**From:** [Eric Moore](#)  
**To:** [Rachael Stevie \(CD\)](#)  
**Subject:** Moore Variance Application  
**Date:** Monday, December 14, 2020 3:46:13 PM

Finally, I see the Dept of Public Works recommends approval based on the following:

SITE PLAN

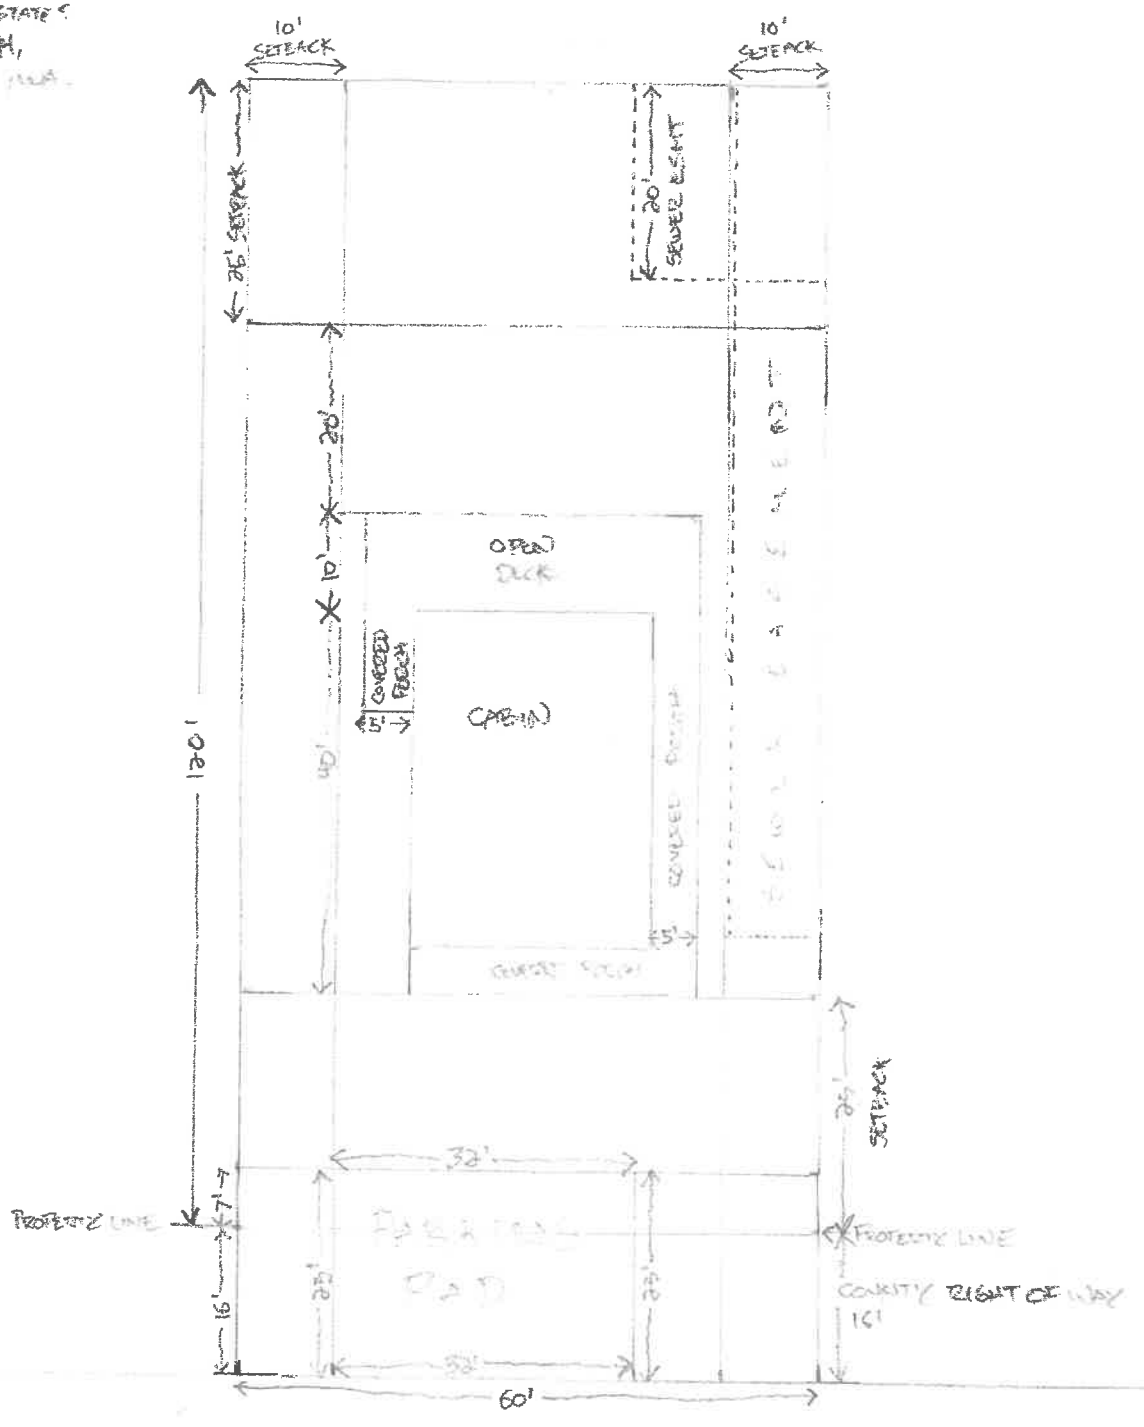
- An access/address permit will be required for the newly created access.
- Kittitas County retains the right to utilize the entire area of the county right-of-way. No structures should be placed in the County Right of Way.

- Please provide engineered drawings of the parking pad which have been reviewed and stamped by a professional engineer. The drawing should contain materials used, slope of the parking pad, contours of the proposed structure and surrounding area, and any other information important to the design.

- Please provide documents which verify drainage on the parking pad and neighboring properties dealt with. Please see the eastern Washington stormwater manual for more information.

- Please provide a barrier on the parking pad to protect vehicles and pedestrians from the steep drop offs

We will make sure we are in compliance with all of these Public Works requests as to ensure approval of this project. Thank you for providing all of the comments and feedback. We look forward to next steps in the application process.
